TO: DRB Chairwoman Wolfley & DRB Members
FROM: District 4 Coalition's Zoning & Development Committee
Jim Griffee, Peggy Neff & Dan Regan, Chair
DATE: 3/29/21
SUBJECT: Project 2019-002761 – The Peaks by Markana

Project 2019-002761 – The Peaks by Markana

LANDSCAPE PLAN

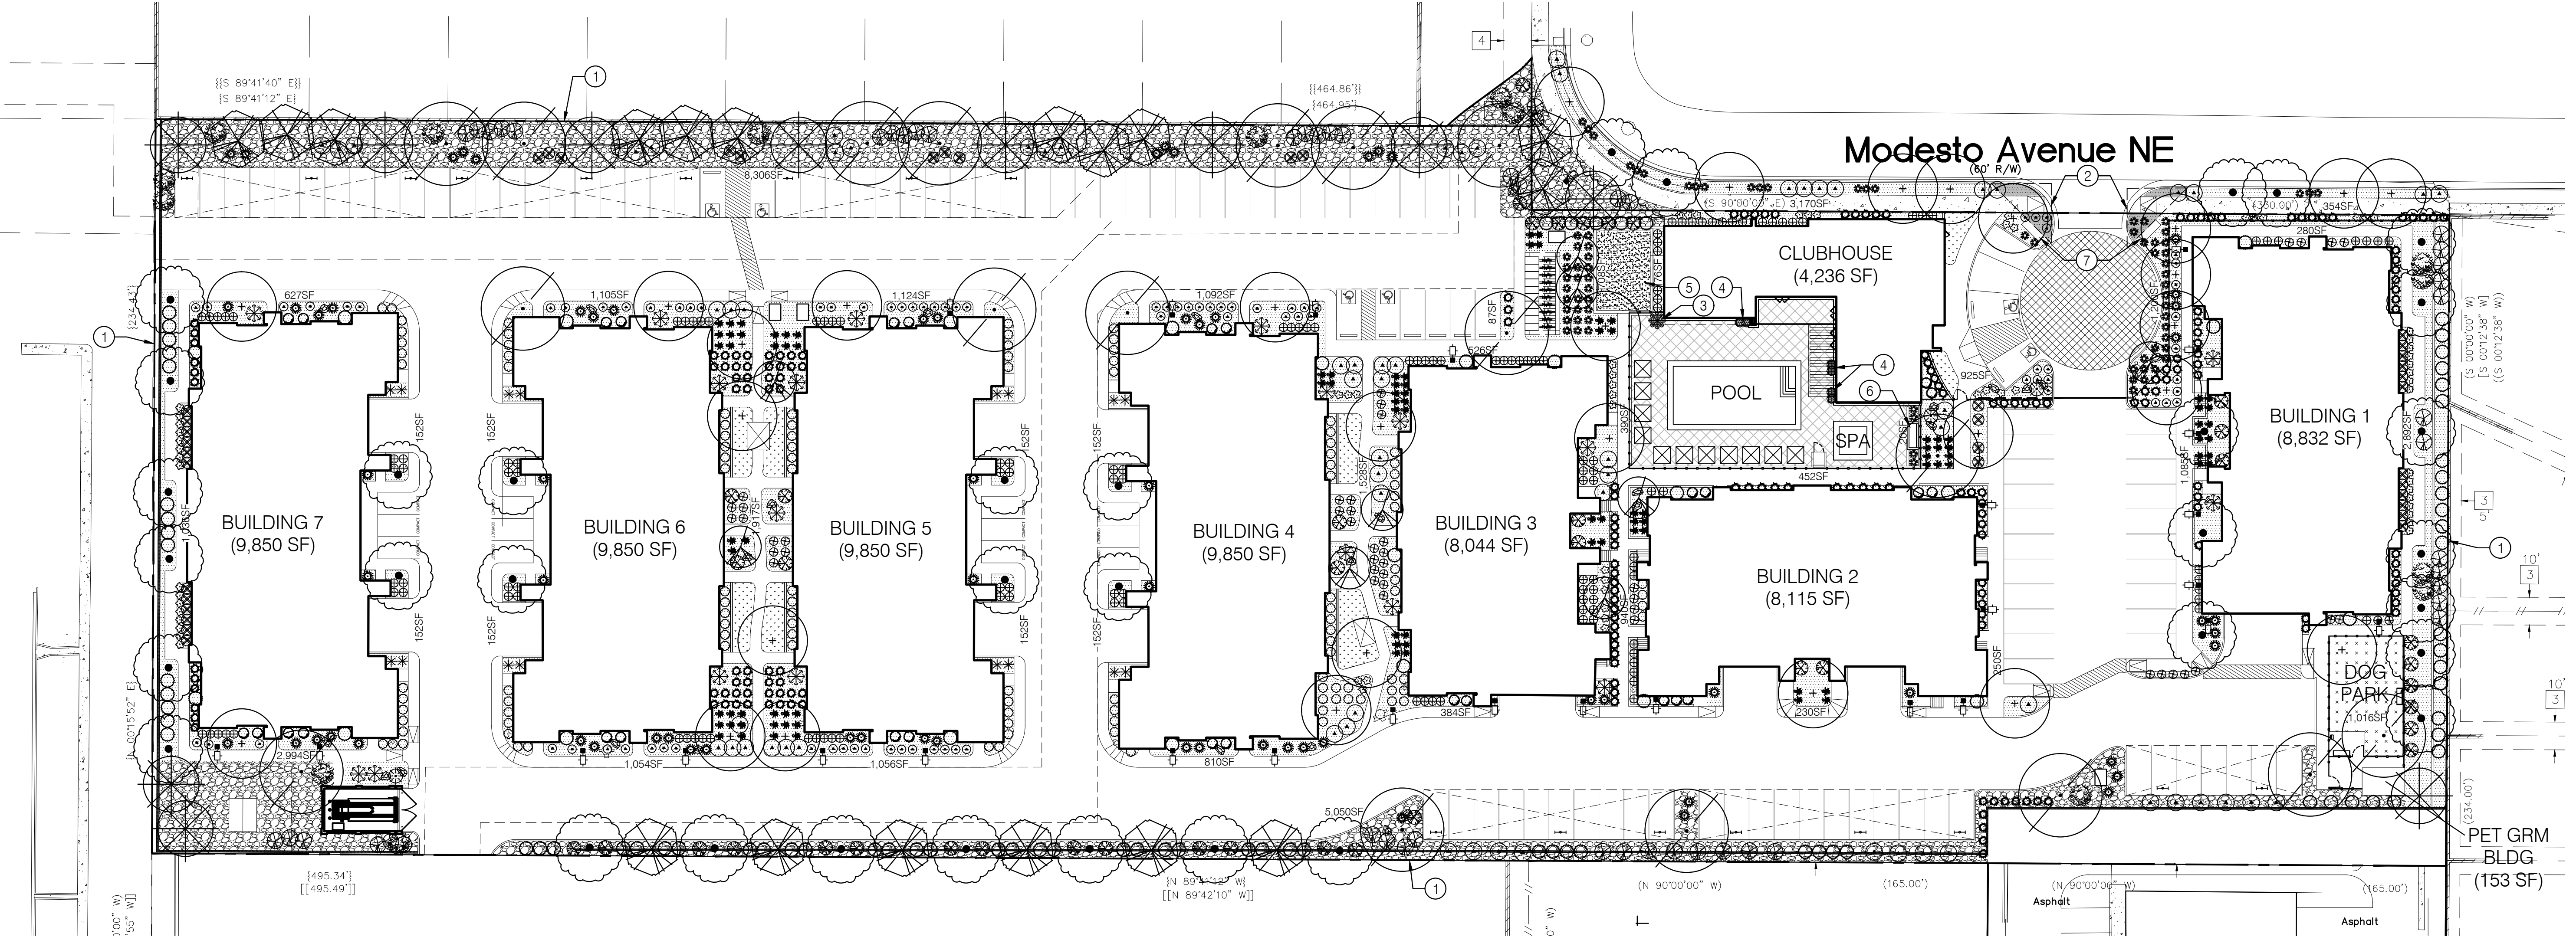
PARKING: The current Site Plan for The Peaks has 120 apartments with 174 beds (in the breakout of single & double bedroom apts.). The developer/agent is required to have 180 parking slots; they are requesting the ability to only provide 174 parking slots (one per bed, conveniently) with NO ACCOMMODATION for ANY visitor parking! If one looks carefully at the immediate surroundings of The Peaks, it is pretty clear that off-site parking of either occupants or visitors will automatically create problems for other residents, both home owners and businesses. The developer would not commit to language in the leases for the Peaks that restrict vehicles to one auto per bed and simply stated that there should be room for Visitors to park. This is not only unrealistic; it borders on the ludicrous! The suggestion that the furthest east apartment building be eliminated or halved and parking be installed there was met with "that won't work" by the developer.
